From: Maria Tomalova <Maria.Tomalova@arun.gov.uk>
Sent: Wednesday, September 13, 2023 5:52 PM
To: Planning.Responses <Planning.Responses@arun.gov.uk>
Subject: FW: Stakers Farm

Please upload the below to the applications Y/105/19 and Y/106/19: Planning Correspondence.

From: Martyn White <Martyn.White@arun.gov.uk>
Sent: Thursday, June 18, 2020 11:07 AM
To: Maria Tomalova <Maria.Tomalova@arun.gov.uk>
Subject: RE: Stakers Farm

Proposed South Elevation (C)

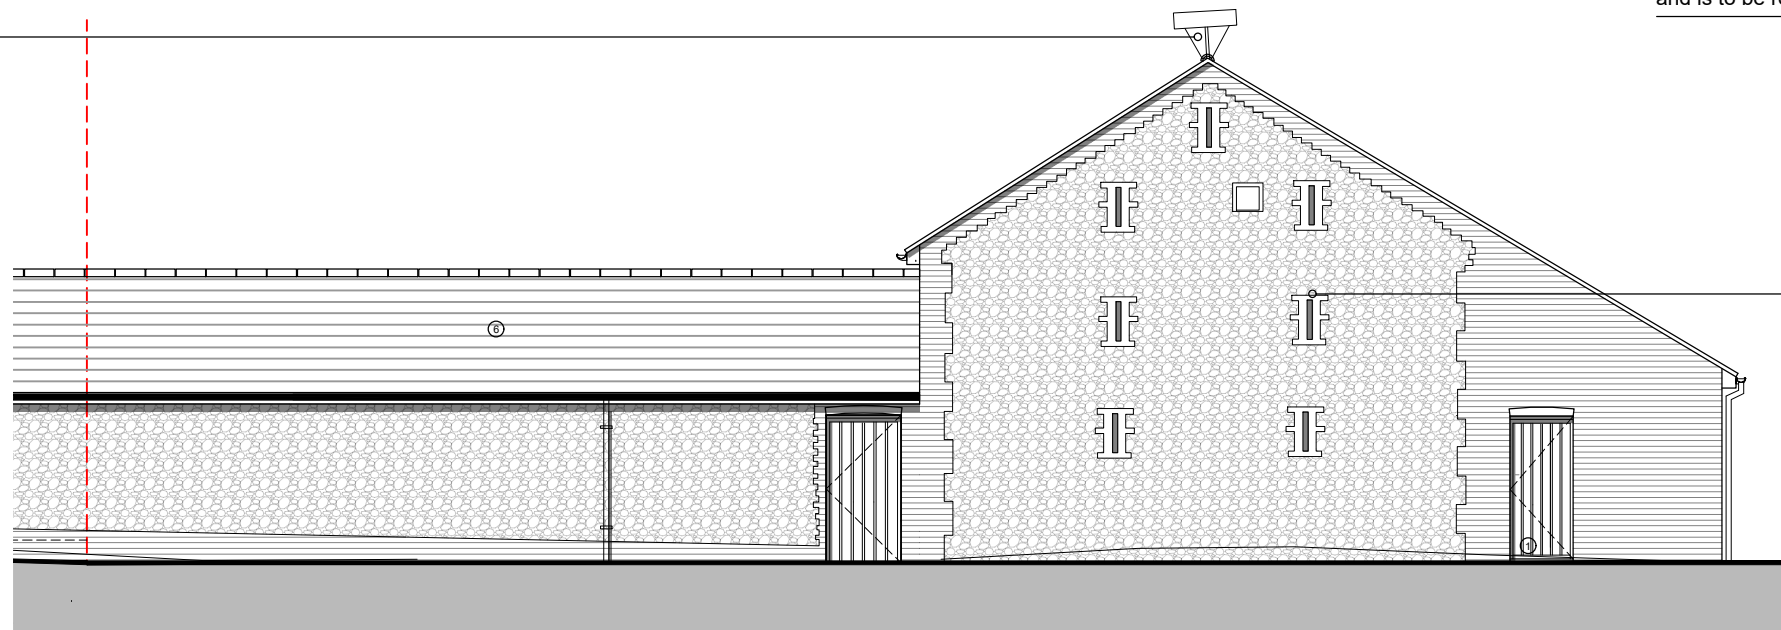
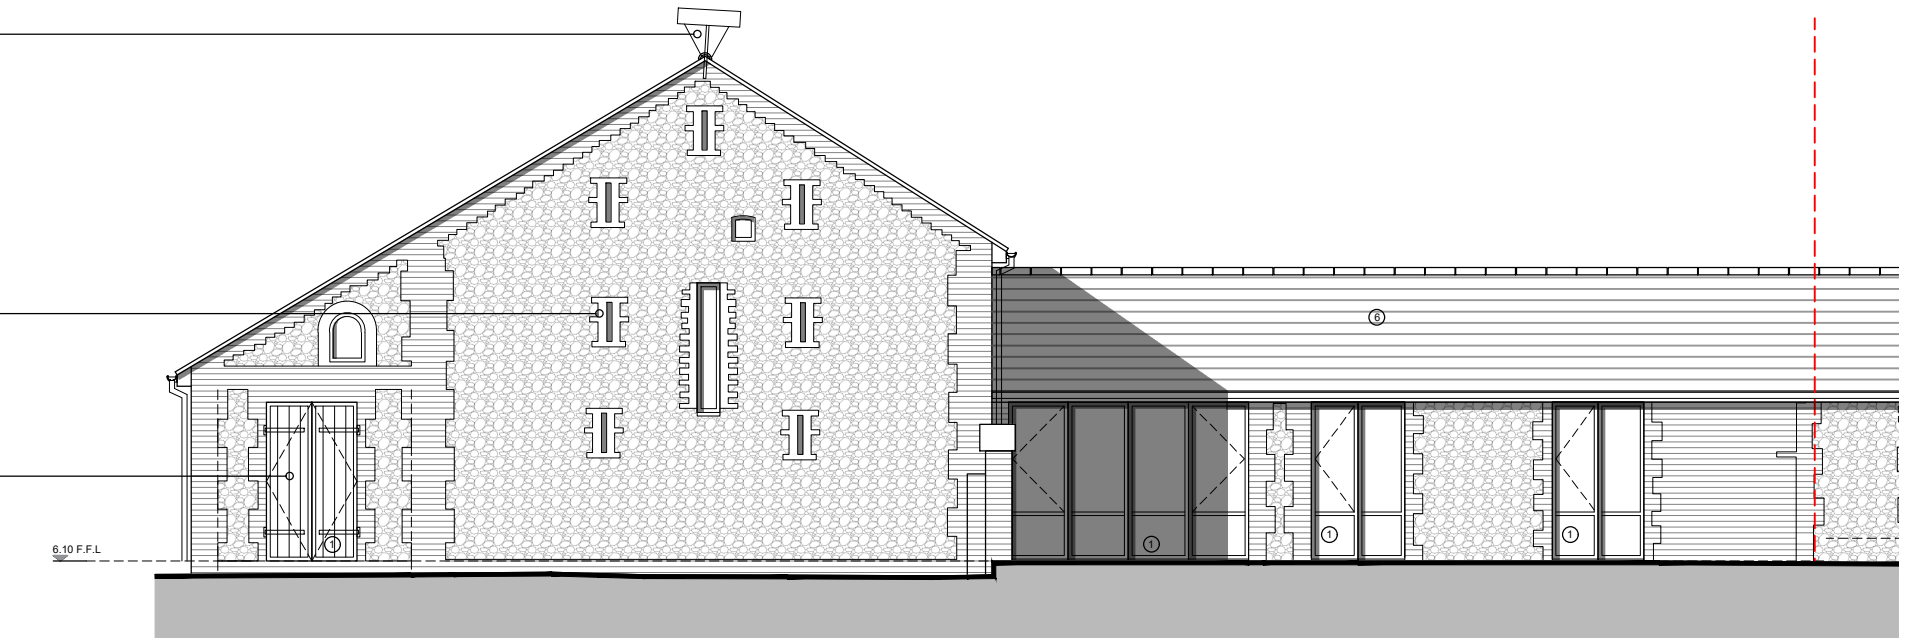
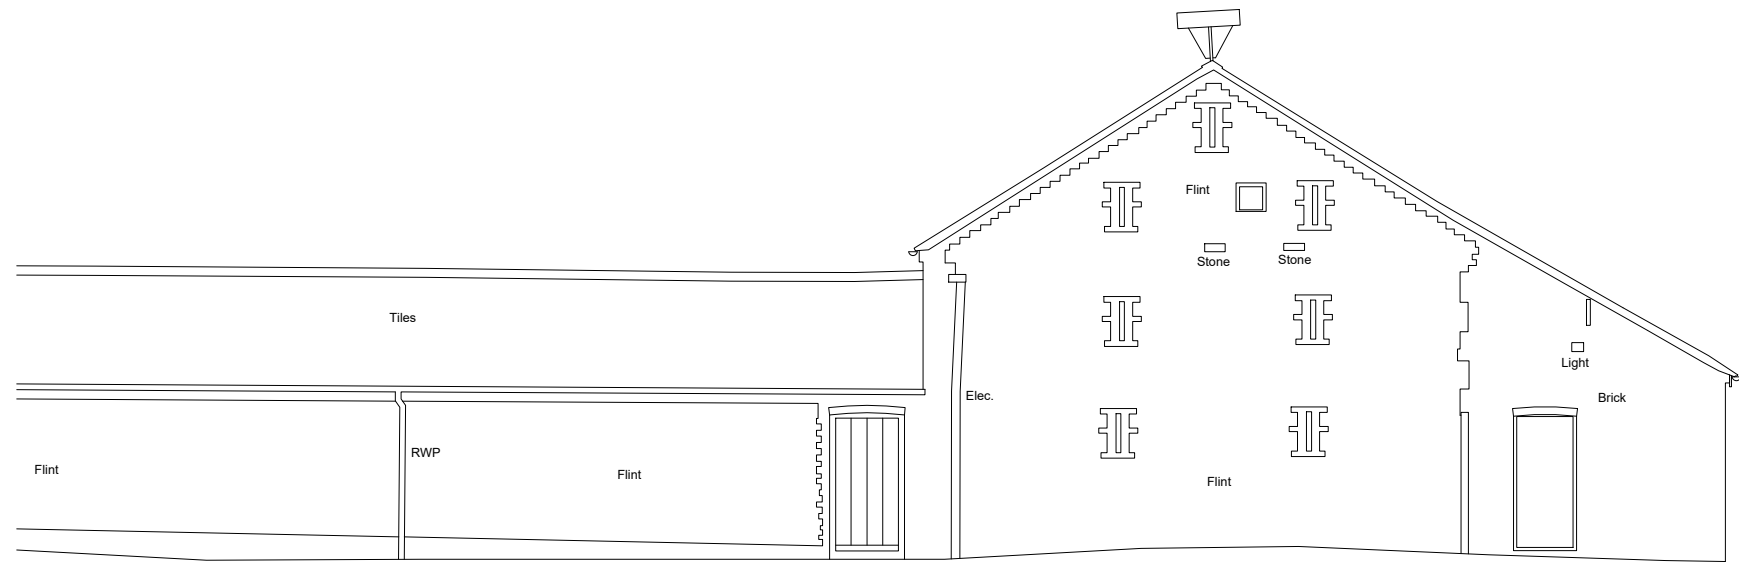
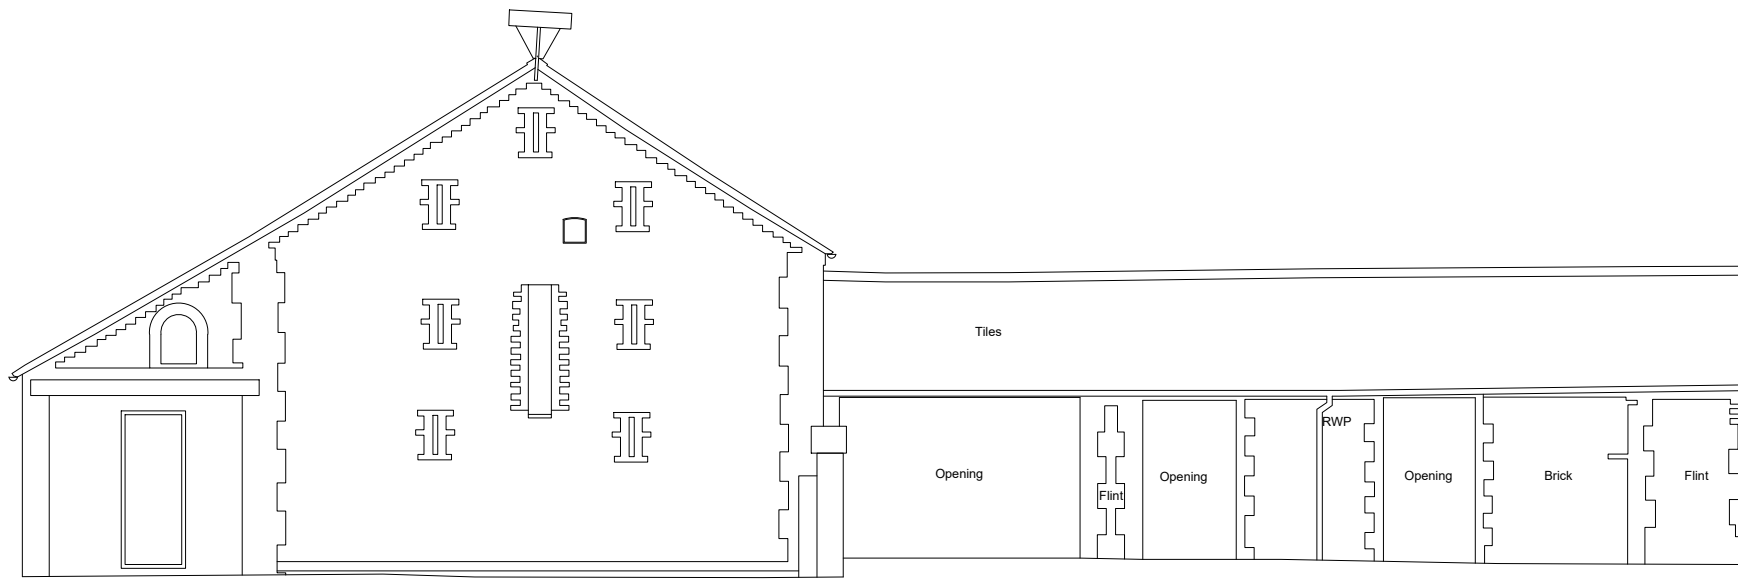
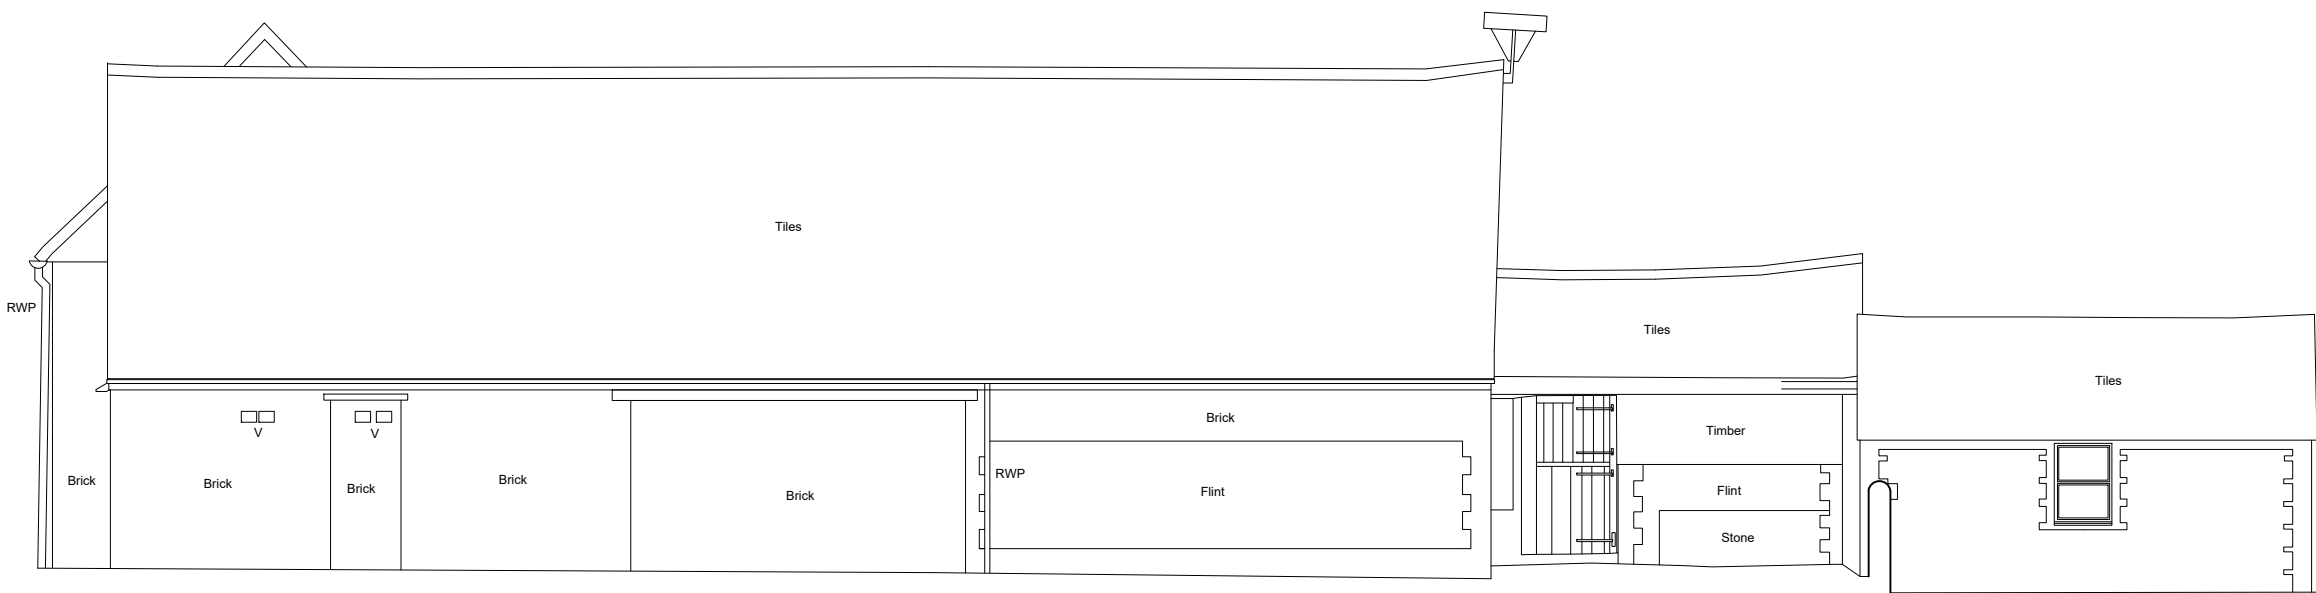
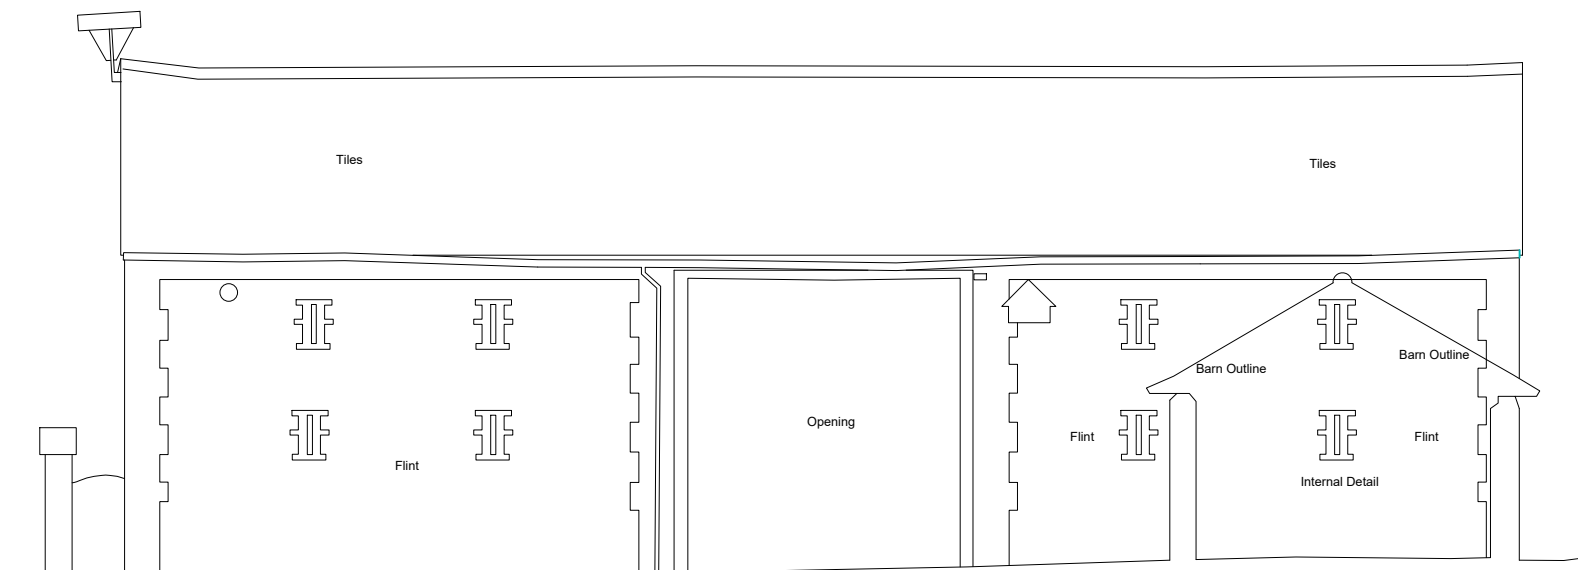
Essentially, the intention should be to maintain the characteristic appearance of the barns as much as possible. The reduction in the rooflights is positive, but it is important that any joinery is simple and unobtrusive. One way to achieve this is to push the joinery further into the opening so that it is not so obvious, whilst also maintaining a shadow line.

East elevation – we will ensure that the single storey element of the barn retains the features of the existing building as far as possible and will not reduce in size the larger existing opening.

East elevation – having regard to the two storey part of the barn, as discussed, we will have a look at how we can improve that part of the barn that was rebuilt at a later date and we will replace the existing unsympathetic door. South elevation – we will remove all of the lower rooflights but will keep the higher ones. We will also reconsider the French doors.

North elevation – we will reduce the number of rooflights as agreed

North-west elevation – we will seek to retain the small existing window by the door and retain the existing door in the single storey element rather than installing a new door.
